#### **Assessment of West Culburra Concept Plan**

Thank you for the opportunity to assess the revised concept plans for West Culburra as forwarded to the NSW Department of Planning and Environment by Martens and Associates on June 8, 2017. I have reviewed their information and have identified some issues as outlined below.

TYPICAL BIOSWALE SECTION  
SCALE 1:20 @ A3

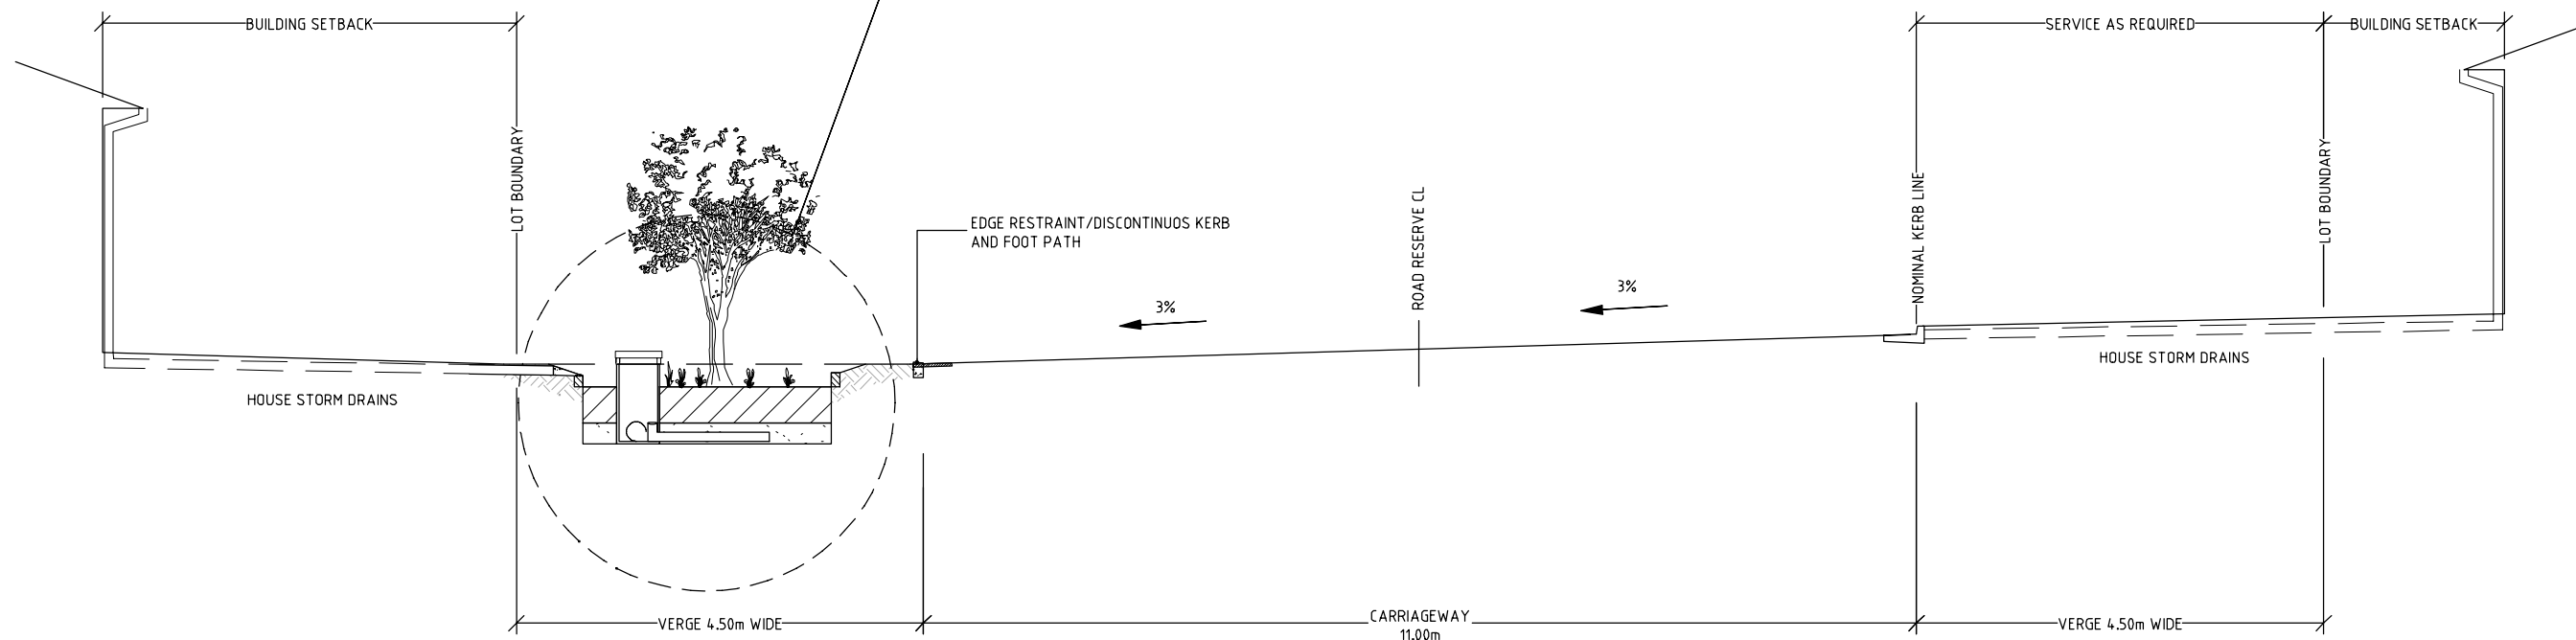
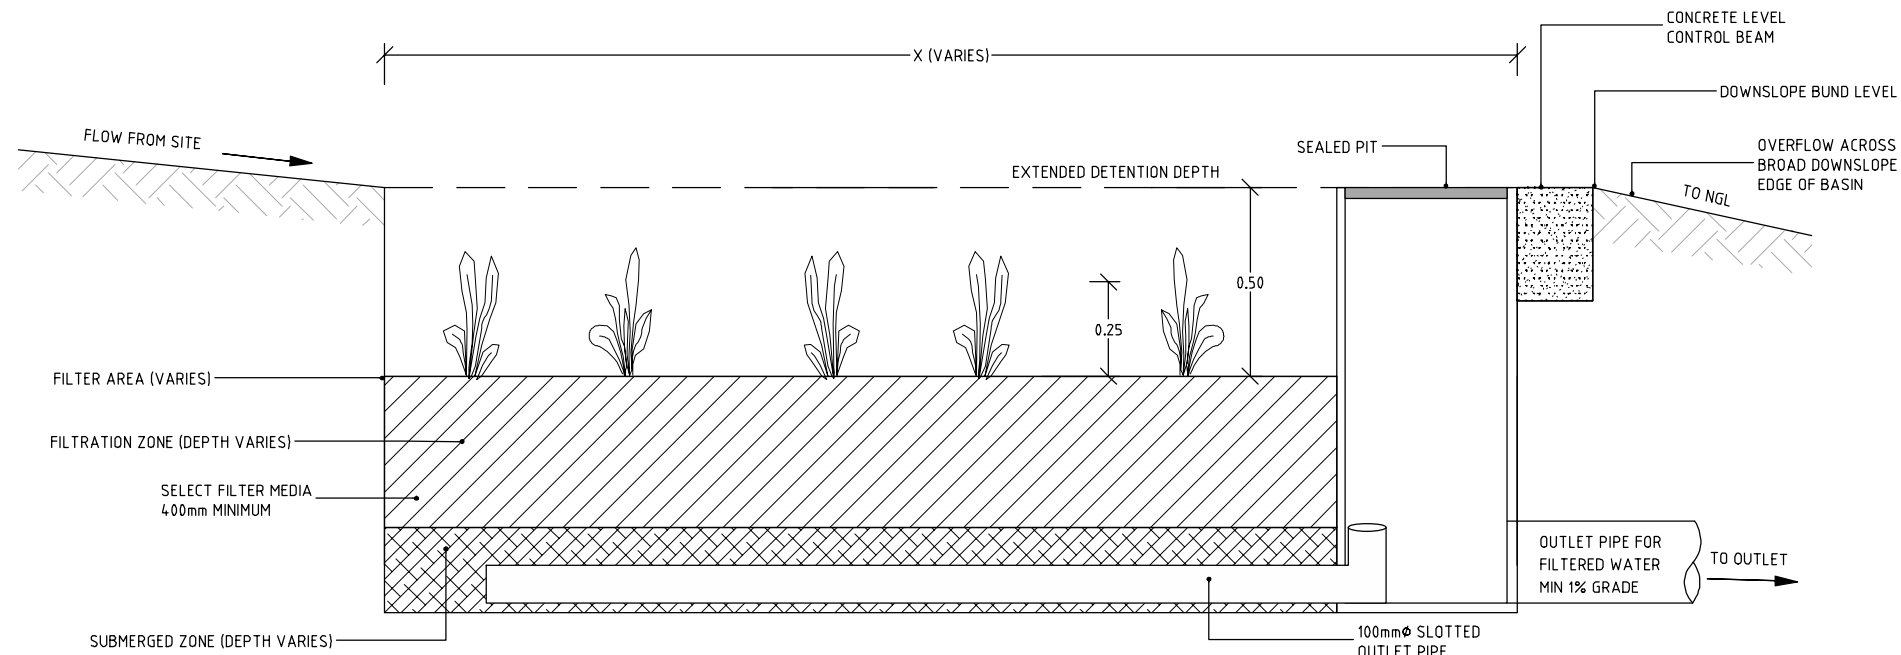
The proposed treatment train has little information with which to verify suitability to the subject site. This includes a lack of information around the configuration of the rainwater tanks, stormwater harvesting demand, and the bioswales.

Having bioswales discharging into Enviropods and Stormfilters is not appropriate as the MUSIC nodes provided by Stormwater 360 for their products (Enviropods and Stormfilters), are not set up to function correctly for

treated stormwater inputs. I therefore suspect that the model is "double-counting" treatment performance and this may be why the proponent has been able to demonstrate a NorBE compliance.
